Planning Application No: 3/2026/0693

Proposal: Proposed construction of an equine menage and native species planting.

Location: Wyncongill Holden Lane Bolton-by-Bowland Clitheroe BB7 4LZ

Proposed Site Plan
Scale 1:500 @ A3

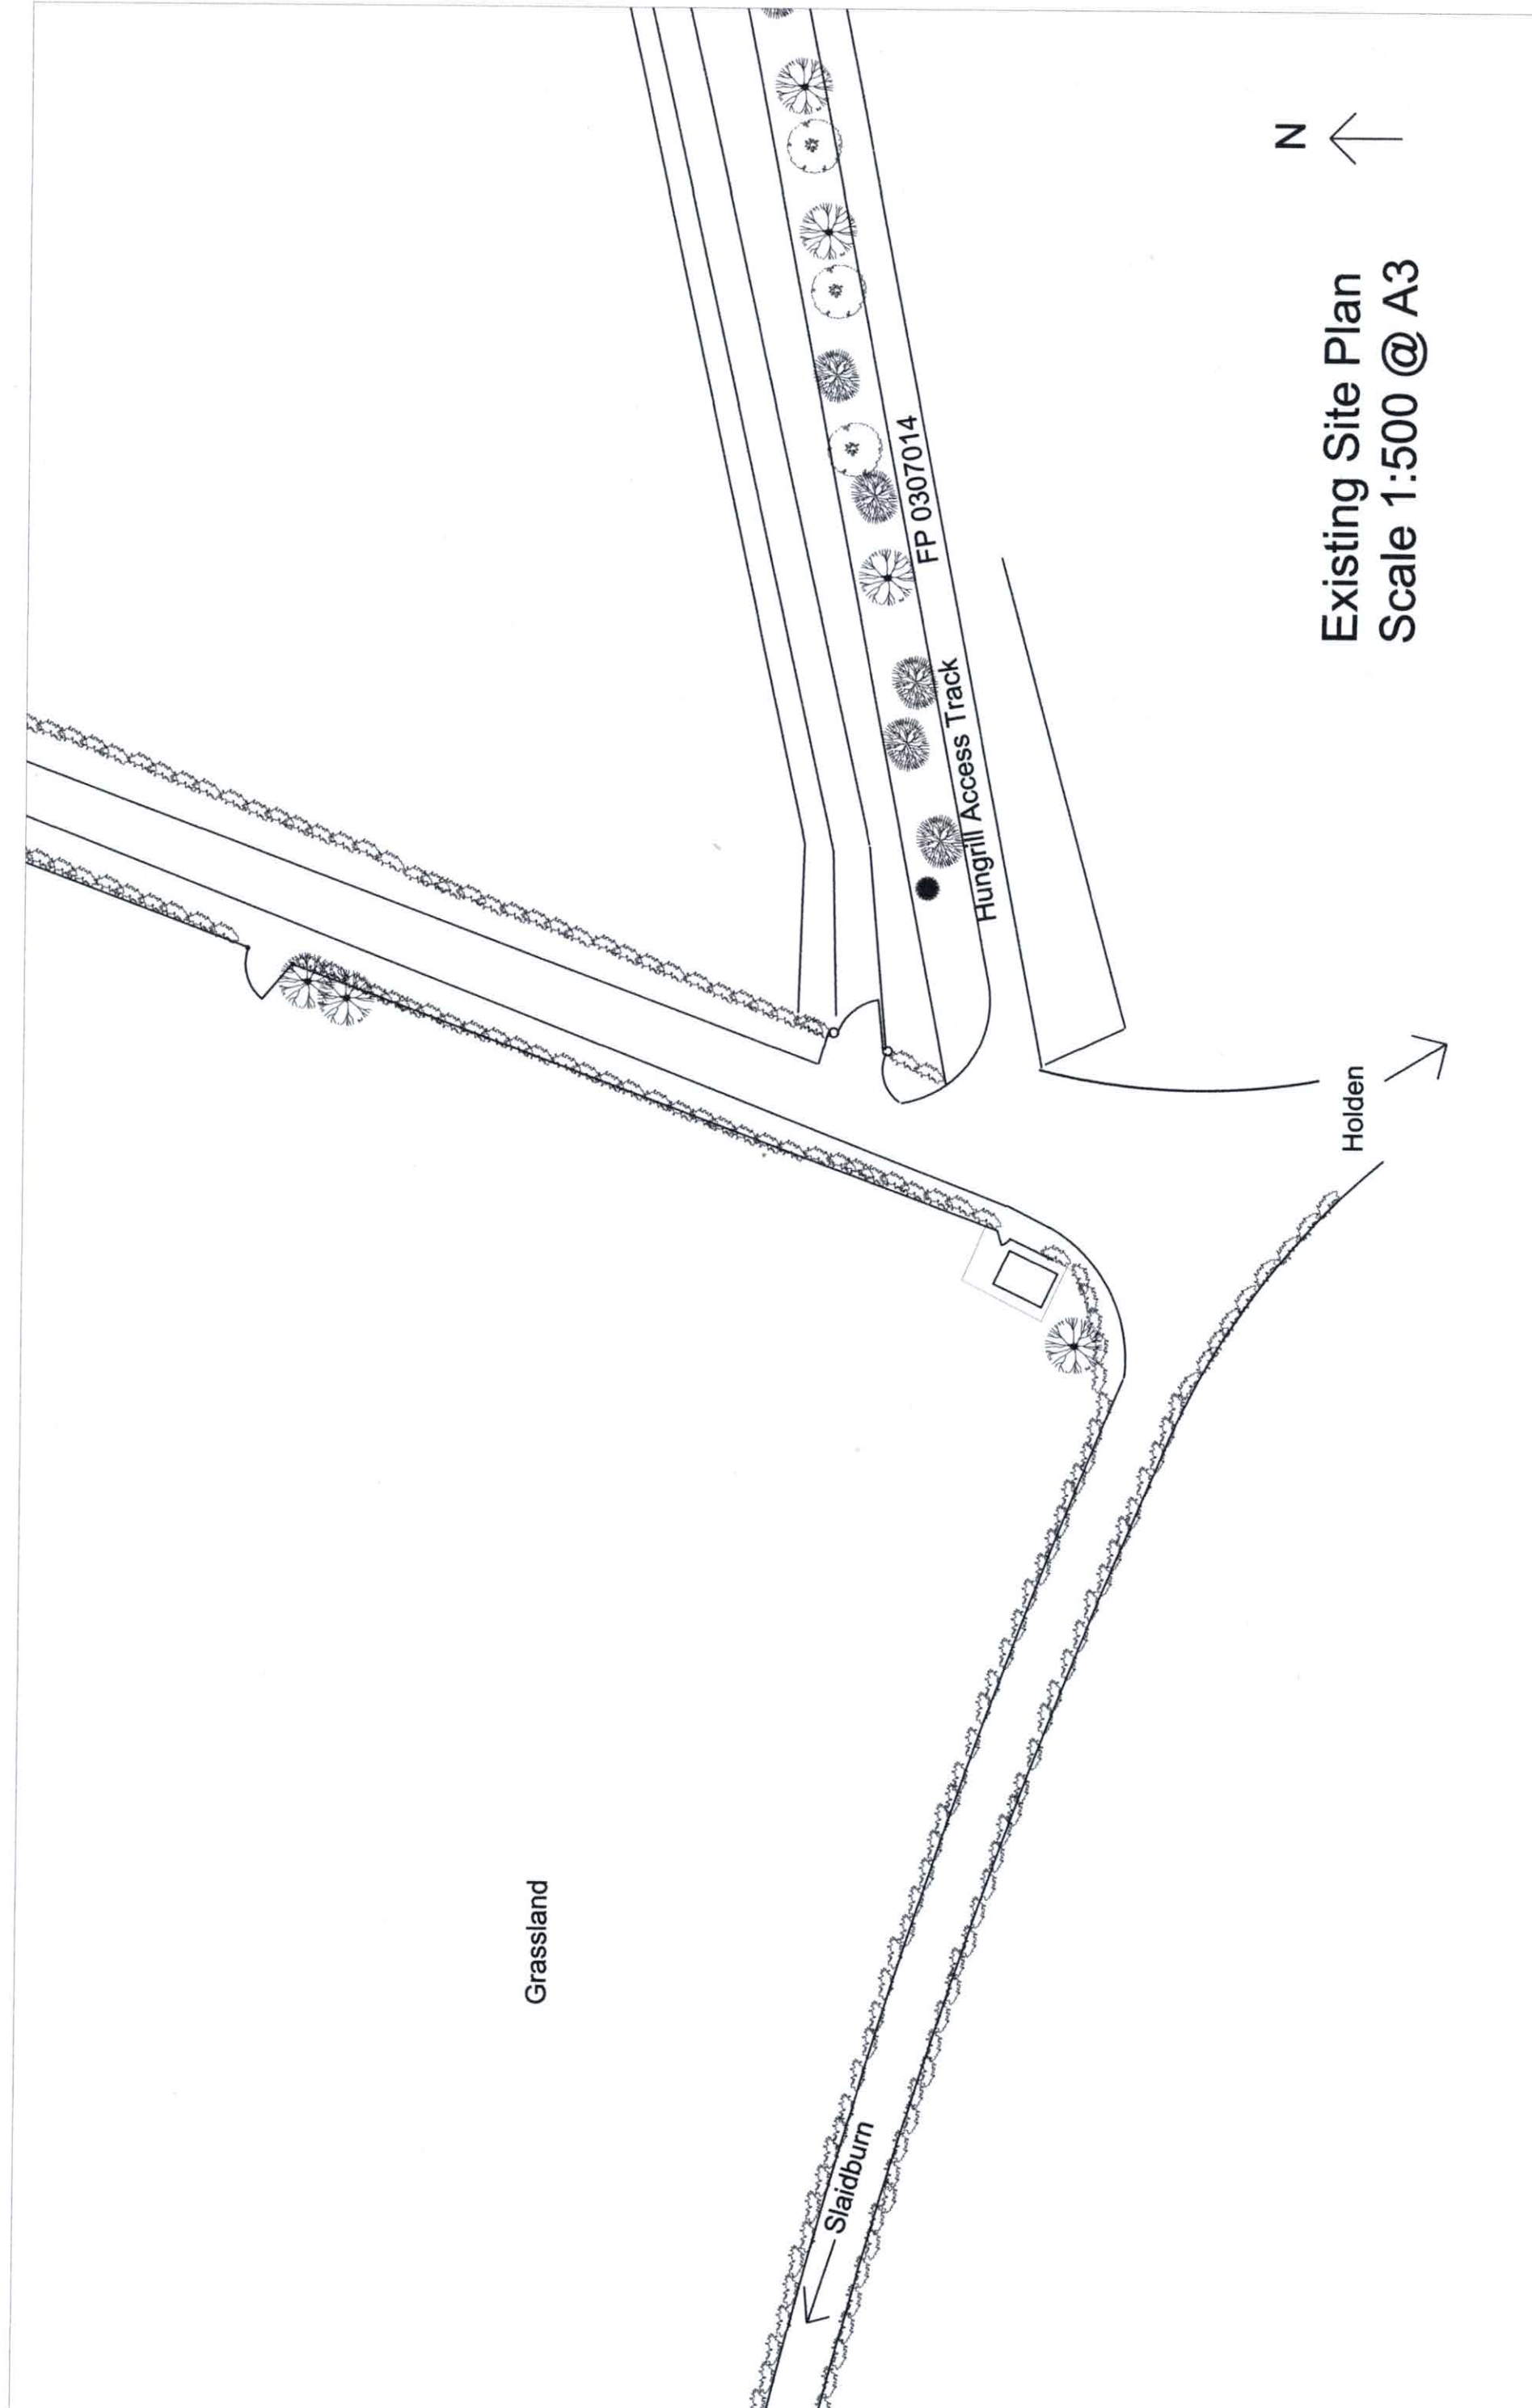
(Ref. Site location plan) Public Right of Way FP0307014 should not be obstructed during construction and landscaping works.
